EL PASO COUNTY PLANNING AND COMMUNITY DEVELOPMENT DEPARTMENT

GRADING AND EROSION CONTROL PLAN CHECKLIST

Revised: July 2019

GRADING & EROSION CONTROL PLAN  
CLAREMONT BUSINESS PARK 2 FIL. NO. 1  
JOB NO. 44-037  
DATE PREPARED: APRIL 28, 2020  
DATE REVISED: JANUARY 11, 2021

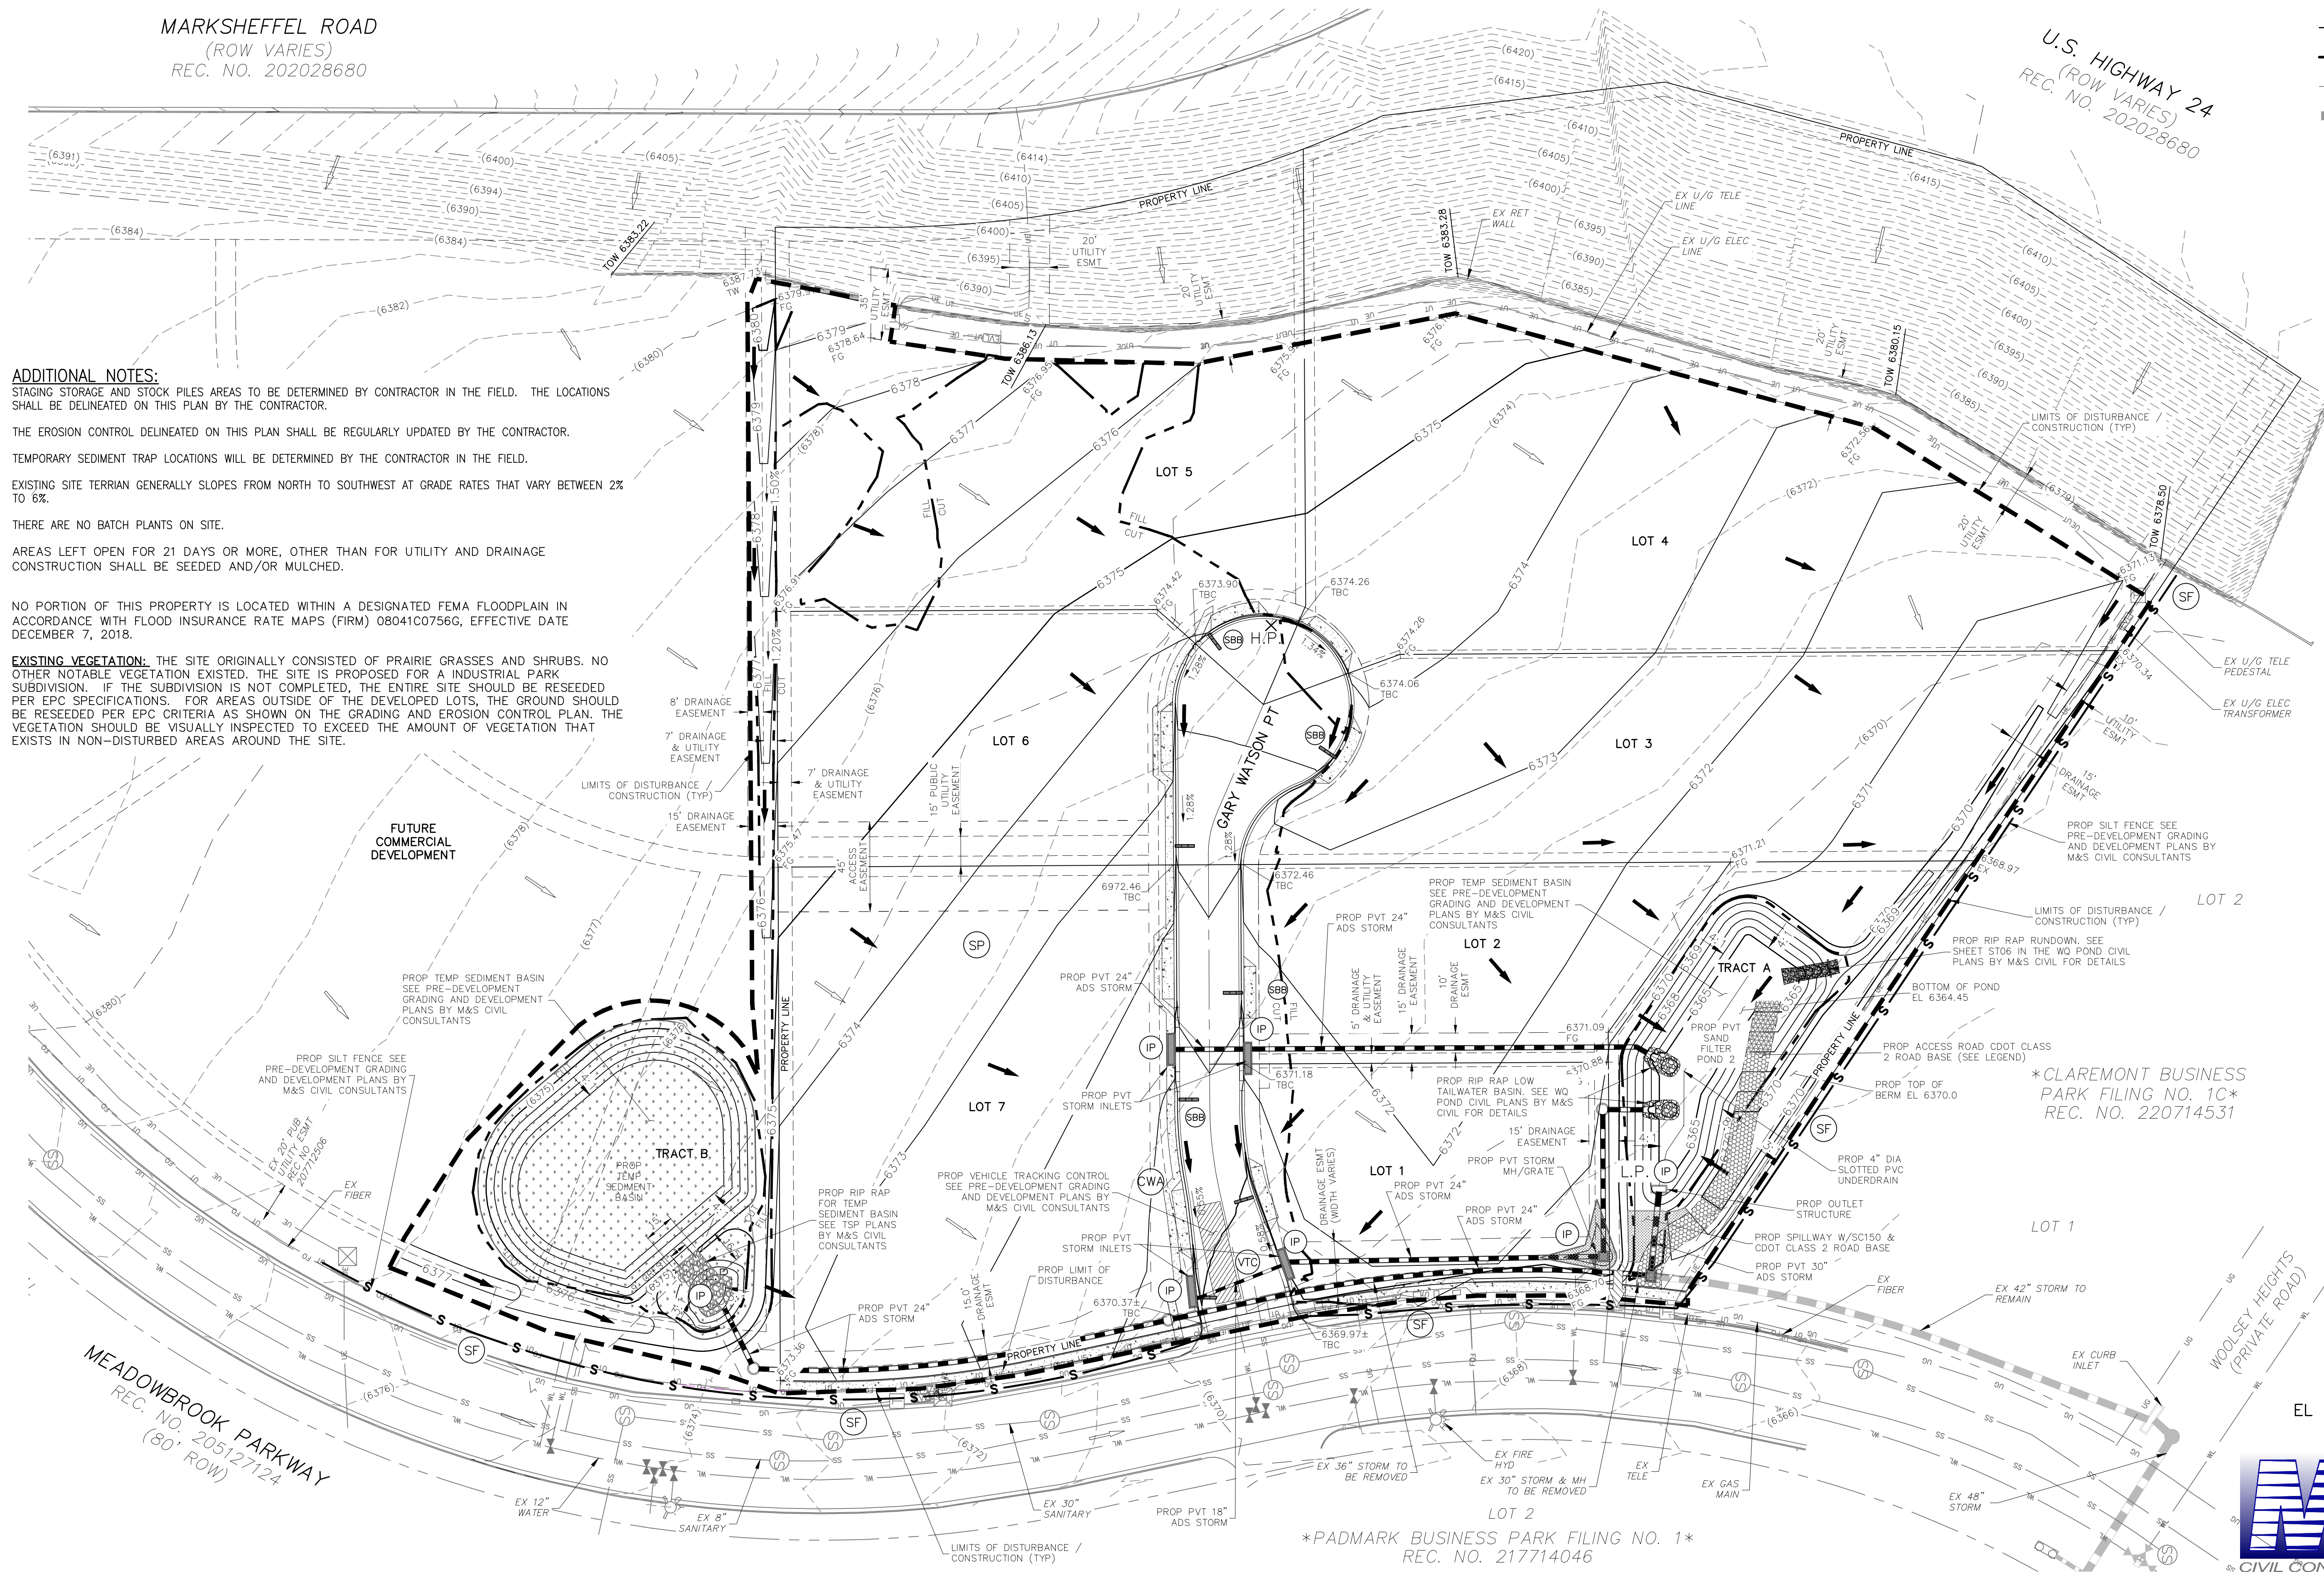
v	All proposed temporary construction control measures, structural and non-structural. Temporary construction control measures shall be identified by phase of implementation to include "initial," "interim," and "final" or shown on separate phased maps identifying each phase. See comments on Sheet 2 of GEC Plans	X	✗
w	Vehicle tracking provided at all construction entrances/exits. Construction fencing, barricades, and/or signage provided at access points not to be used for construction.	X	✓
x	Temporary sediment ponds provided for disturbed drainage areas greater than 1 acre.	X	✗
y	Dewatering operations to include locations of diversion, pump and discharge(s) as anticipated at time of design.	N/A	N/A
z	All proposed temporary construction control measure details. Custom or other jurisdiction's details used must meet or exceed EPC standards. See comments on Sheet 2 & 3 of GEC Plans	X	✗
